# CITY OF ALBUQUERQUE

Re: Adelante Phase III, 3900 Osuna Road NE, Traffic Circulation Layout  
Architect's Stamp dated 3-31-05 (E17-D8A)

**Re: Adelante Phase III, 3900 Osuna Road NE, Traffic Circulation Layout  
Architect's Stamp dated 3-24-05 (E17-D8A)**

SHEET SP-1
PROJECT NUMBER 04035

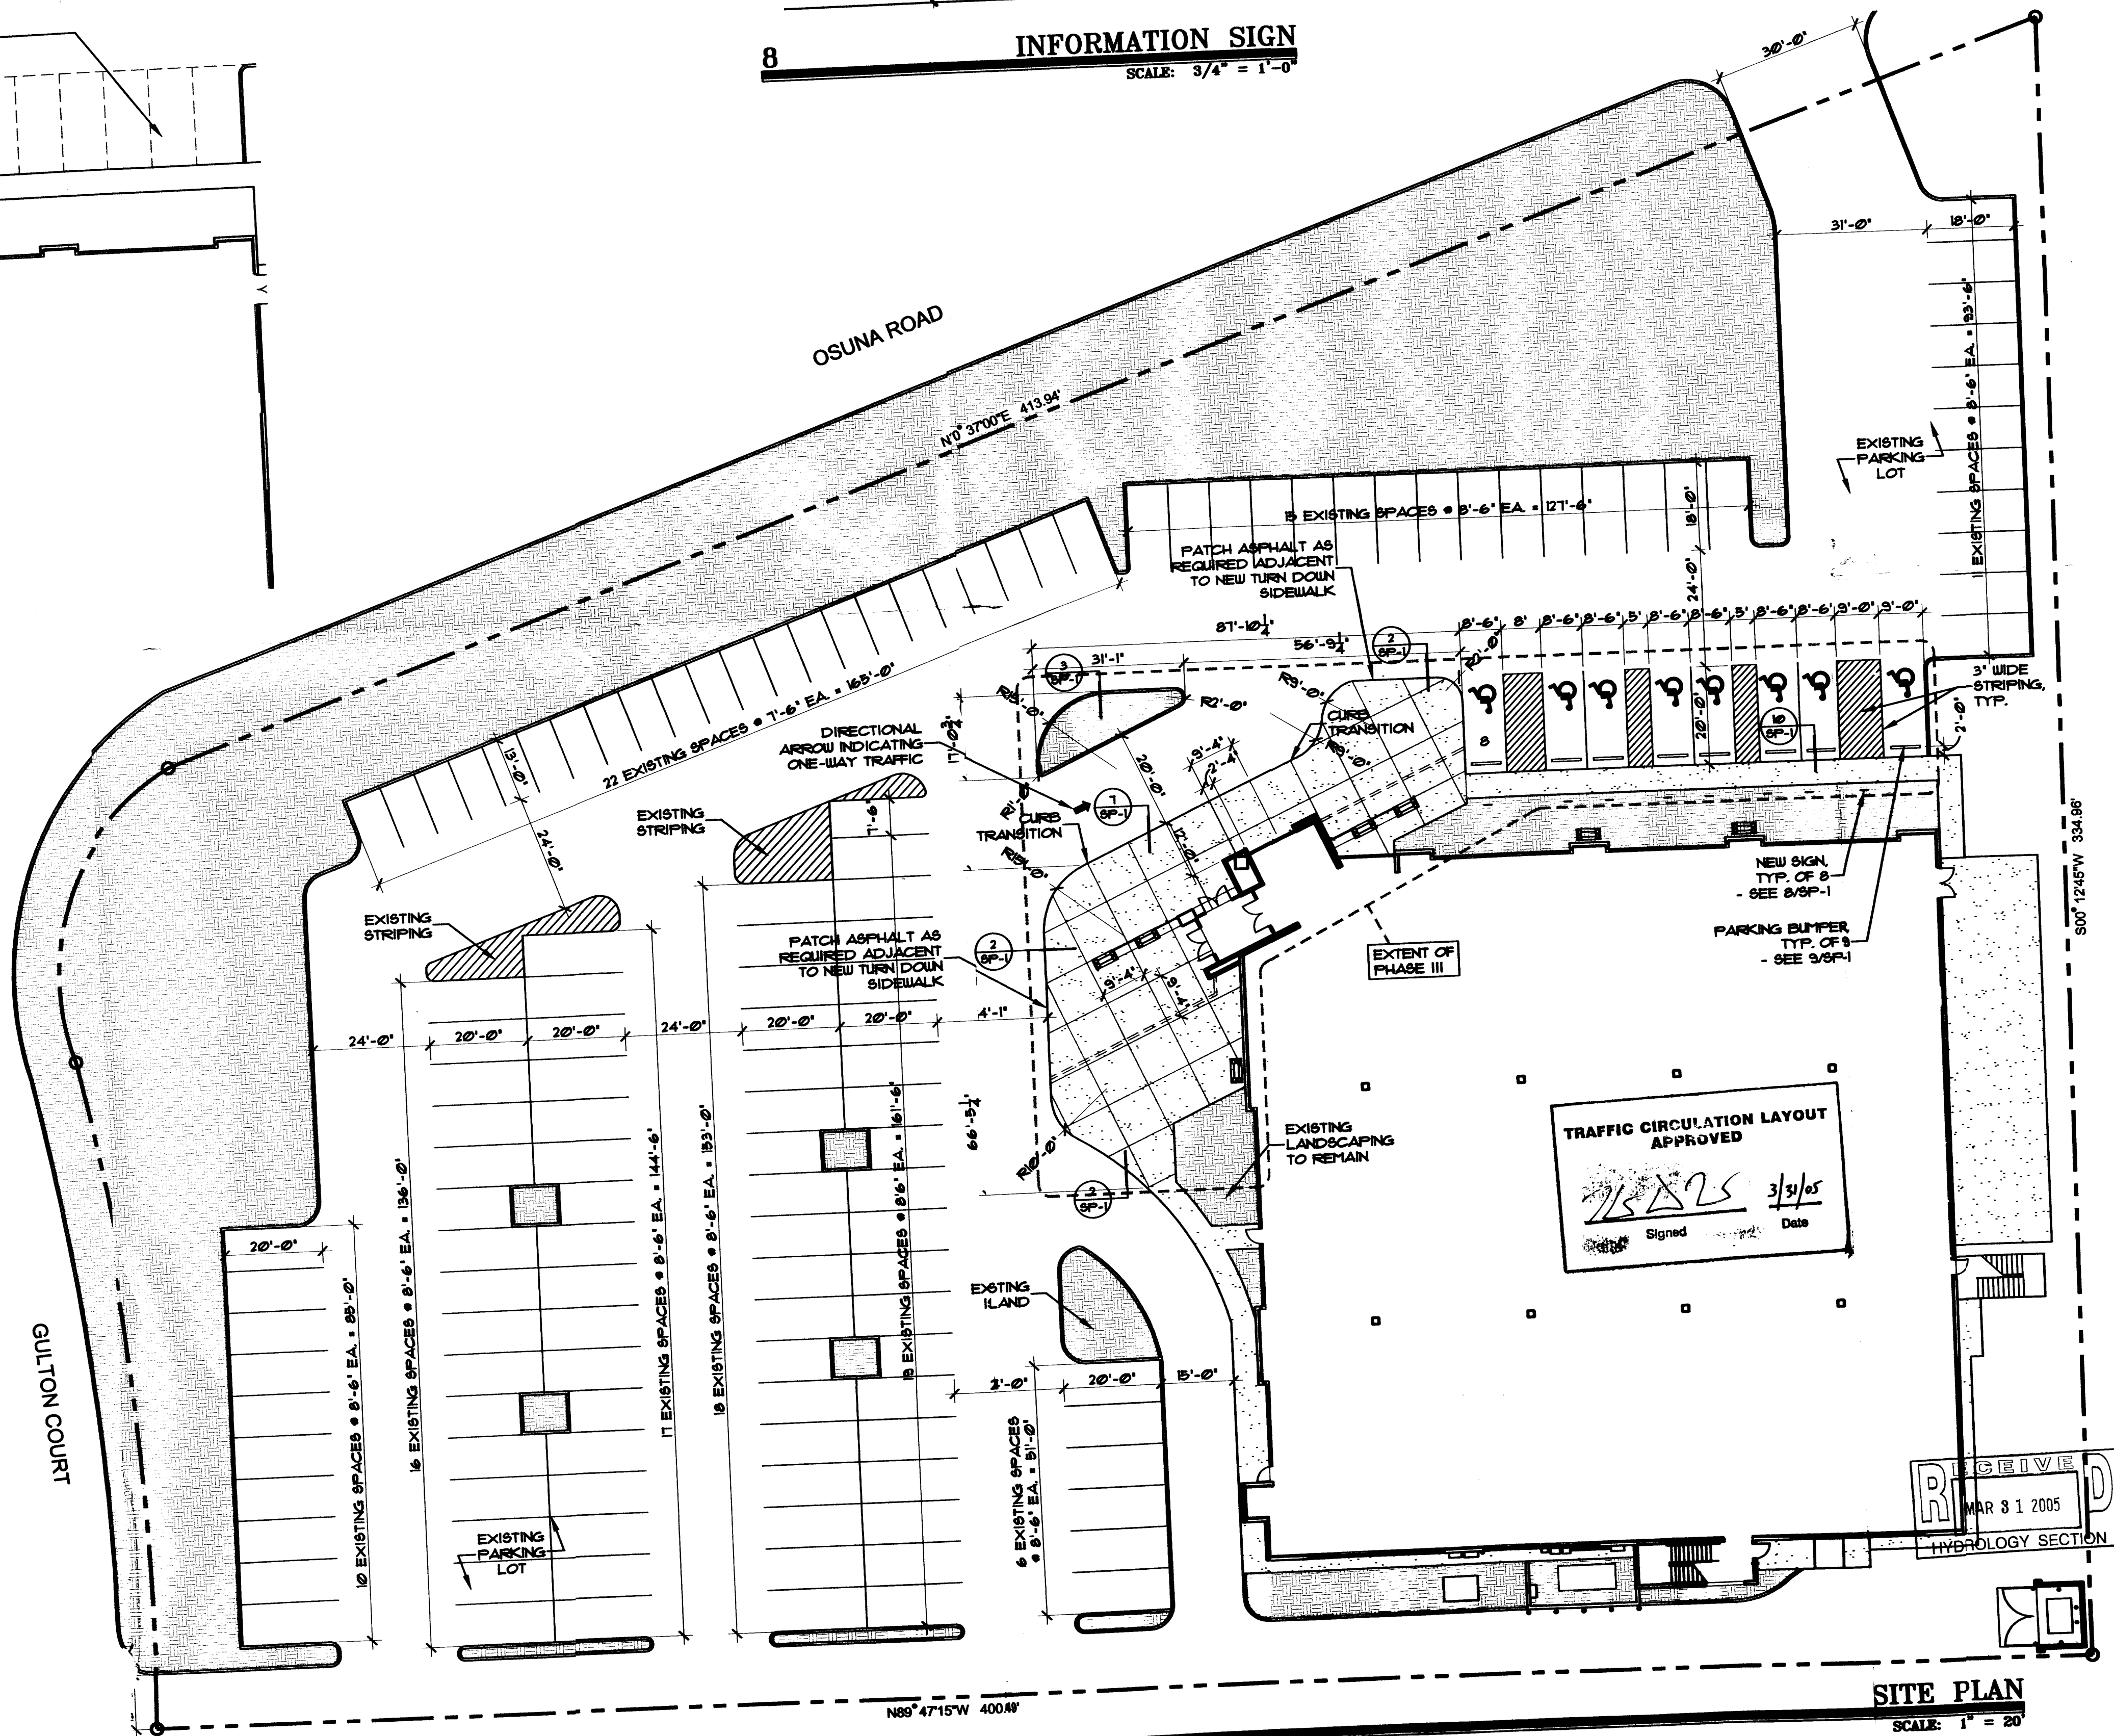
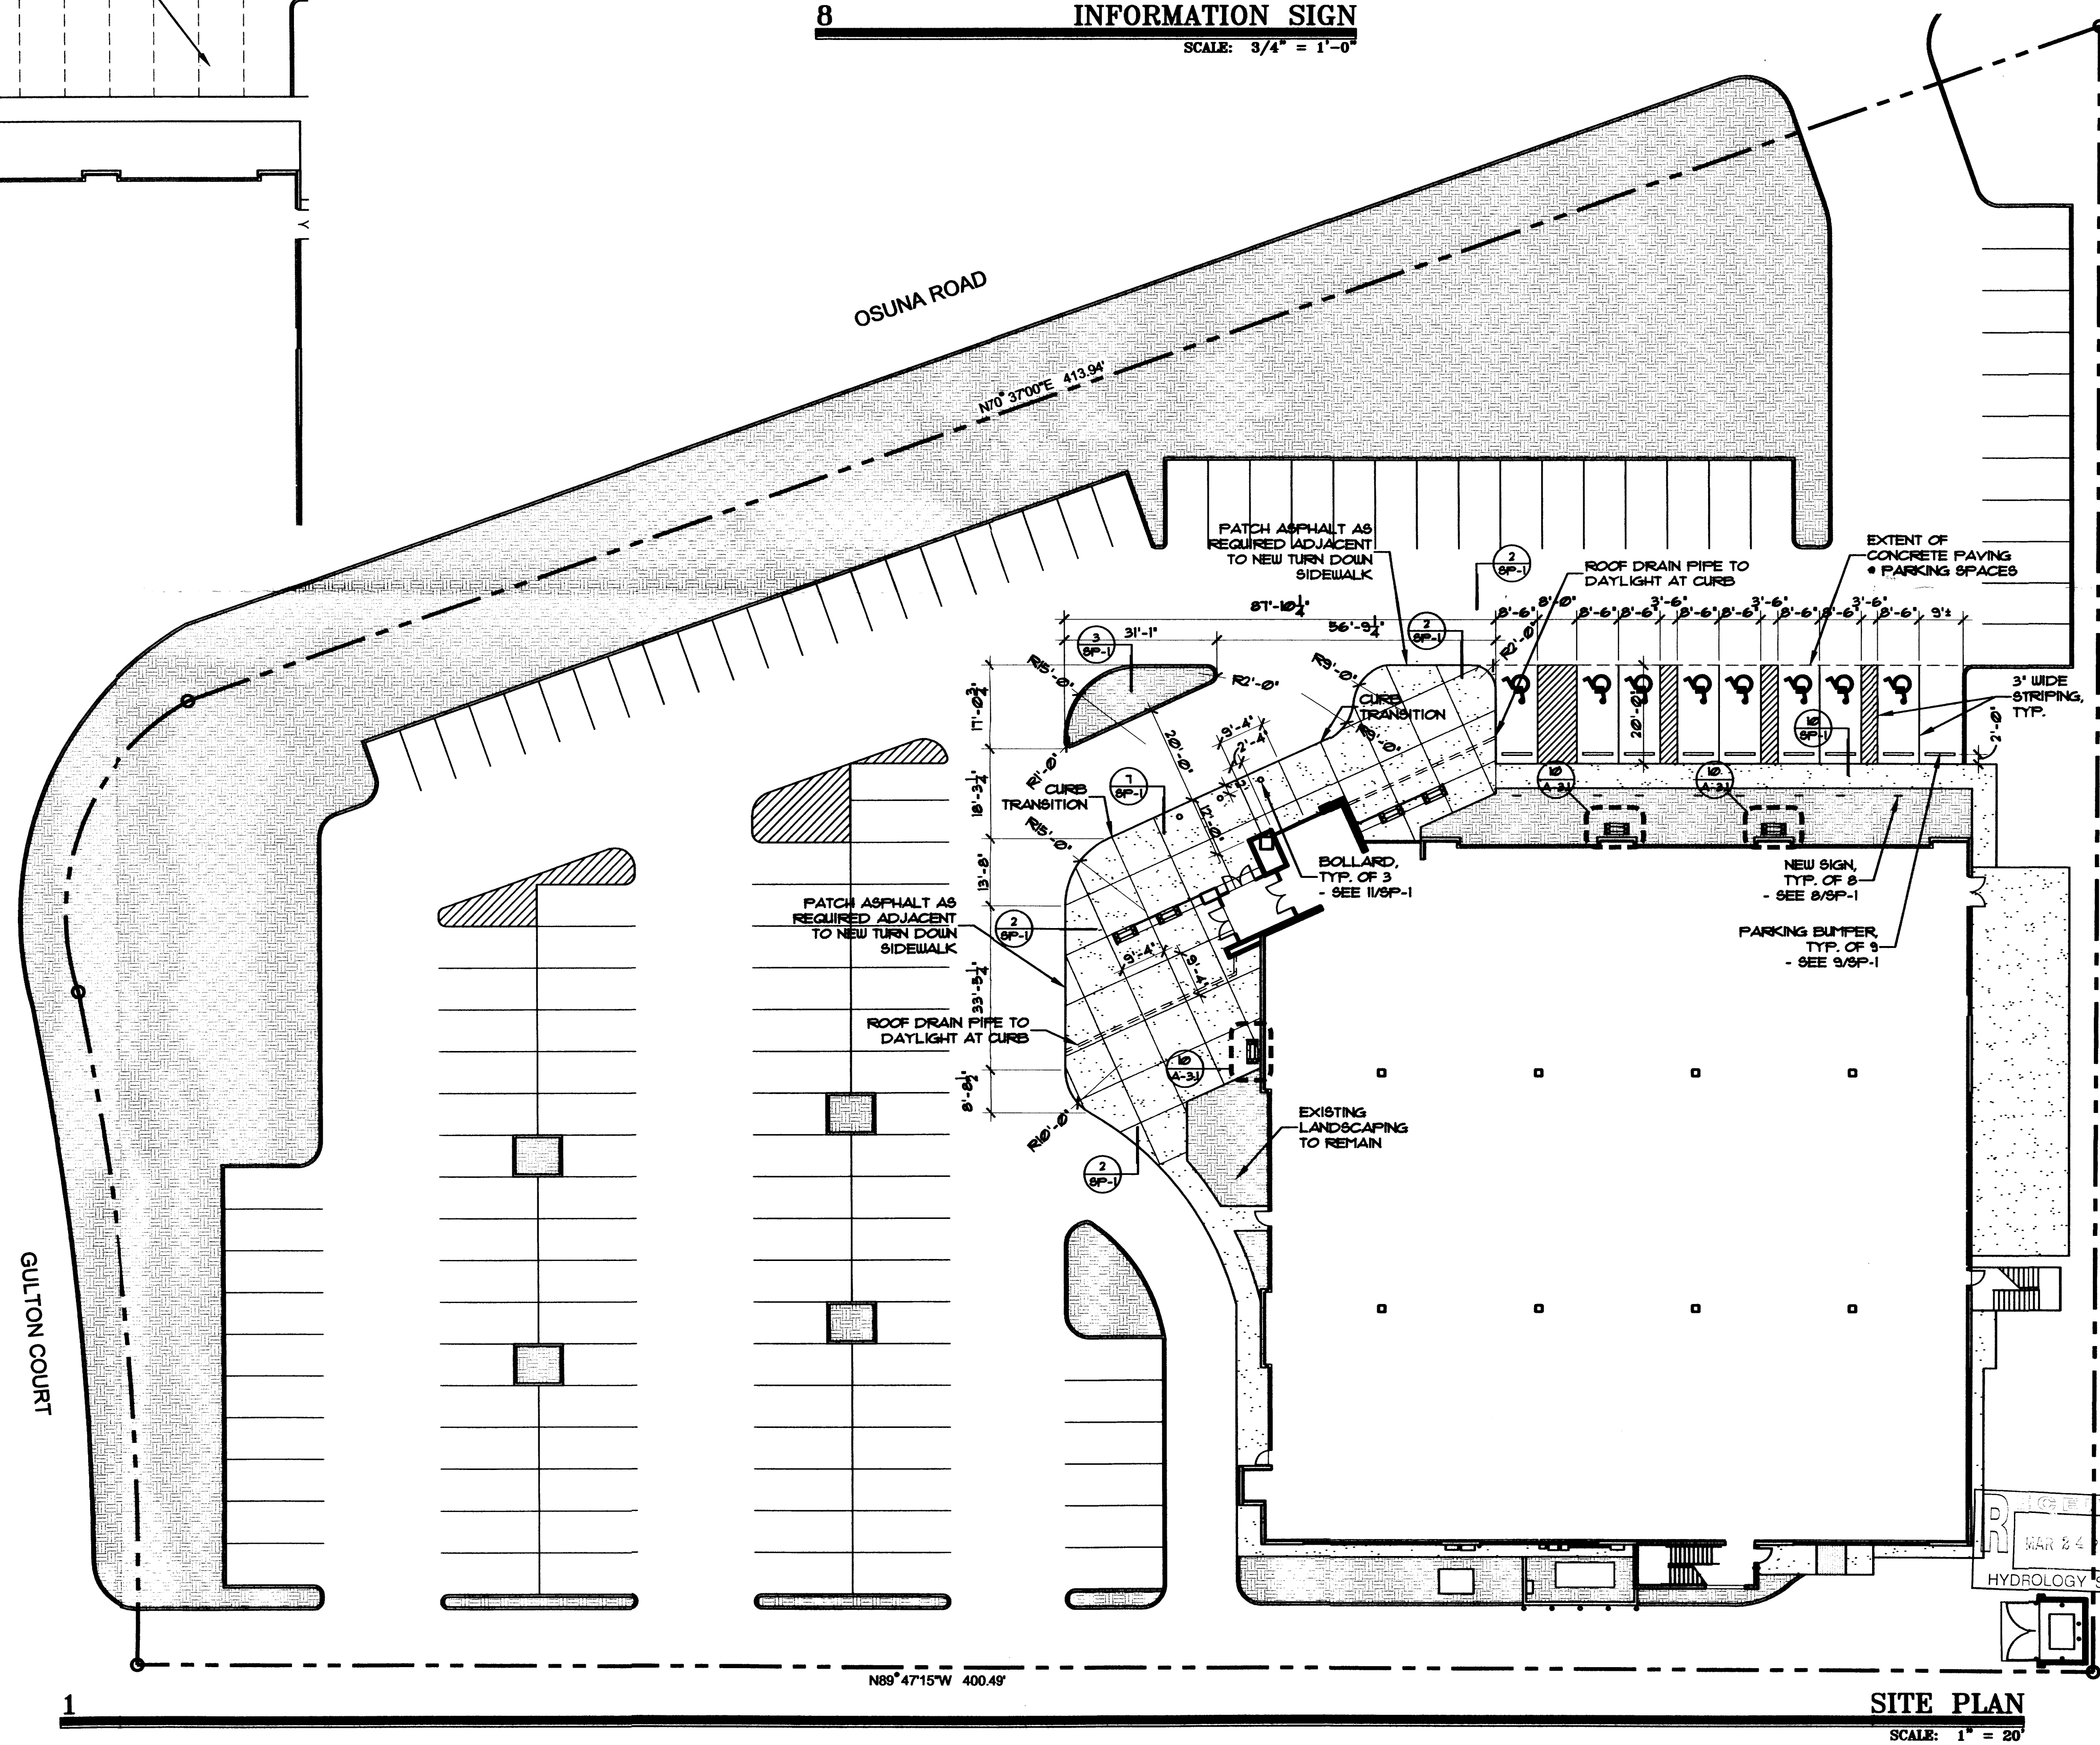
1. Please list the width and length for all parking spaces.
2. List the number of parking spaces required by the zoning code as well as the proposed number of parking spaces.
3. Clearly define all existing versus proposed conditions.
4. Do all areas allow two directional traffic flow? If not, all one-way areas must be clearly signed and striped.
5. Clarify the extents of the current phase.
6. List the width of all aisles and turnouts.
7. The handicapped spaces must include an 8-foot wide van access aisle; all other aisles should be 5 feet in width.

Existing versus proposed conditions  
Extent of current Project

8' van access? 5' regular aisle

Aisle widths

Parking Cycles

Any one way access? Must have present  
stripes? signage
